From: Hill, Grace <Grace.Hill@e-lindsey.gov.uk>
Sent: 15 January 2026 11:25
To: Niland, Mark
Cc: _planningadvice; De-Ruyck, Chris (ELDC)
Subject: RE: Consultation

H20-0933-24 - POPLAR FARM

# **Pre-Development Plan Baseline Map**

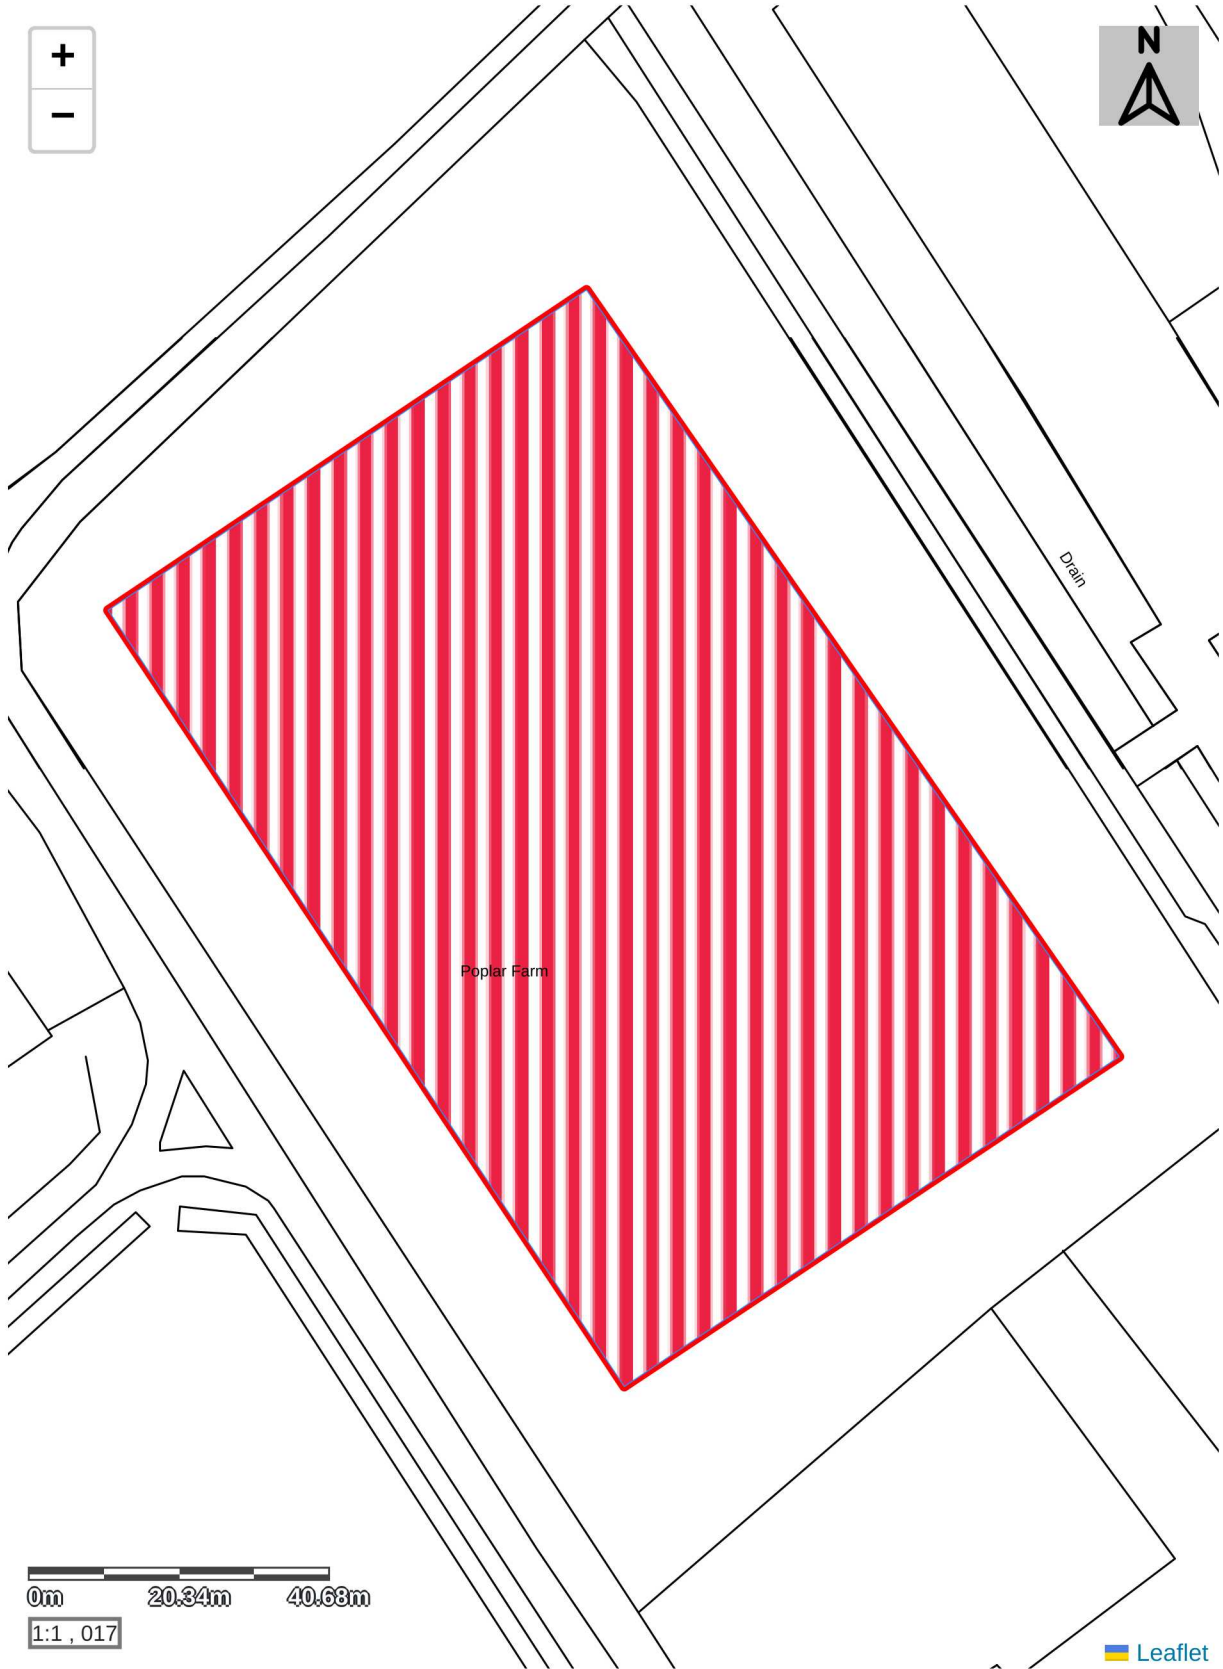
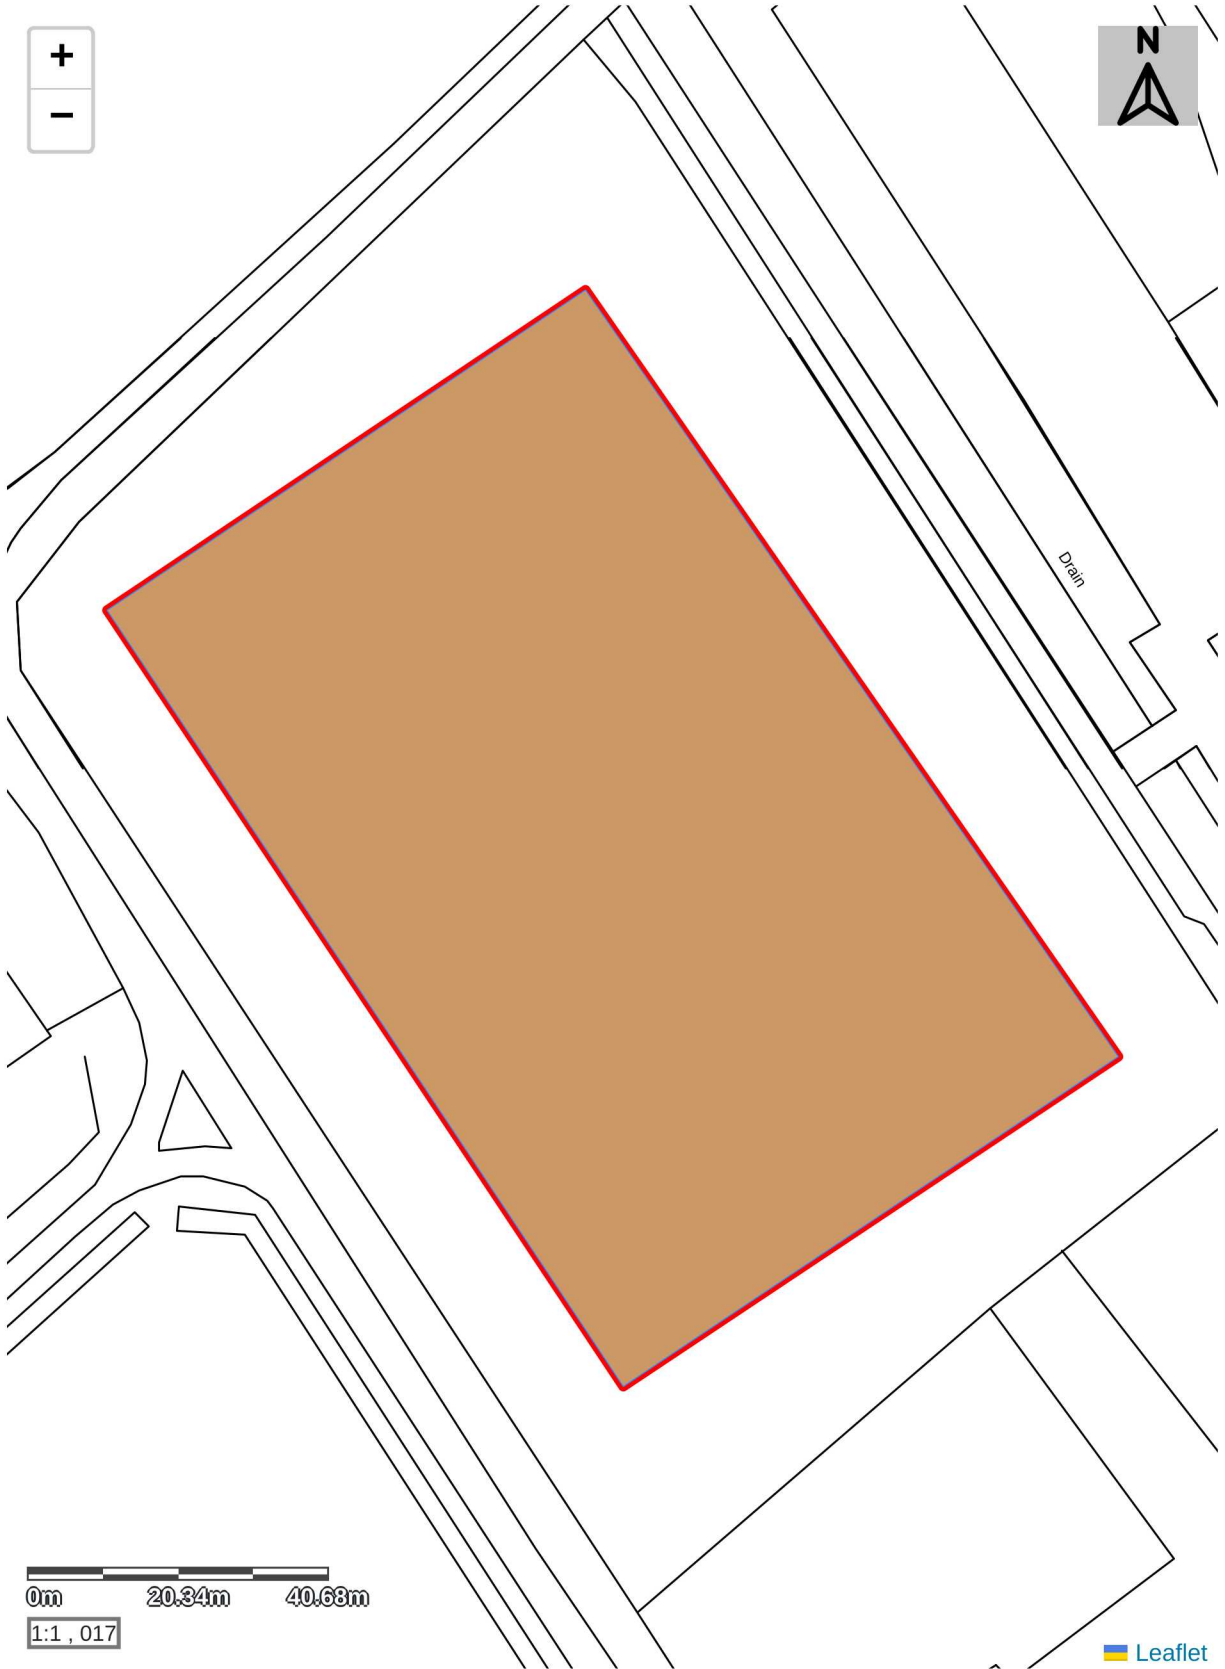
Thank you for following up on this. I appreciate the thorough detail the applicant has provided to justify exemption from BNG for this site. However, it is evident from satellite imagery dating back to 2020 and google street view imagery from June 2023 that most of the site where the proposed building footprint is to be, is composed of either arable cropland or modified grassland (please see images attached).

We will require a full BNG assessment to be carried out on this site including: a full BNG metric, condition assessments where appropriate and baseline habitat maps.
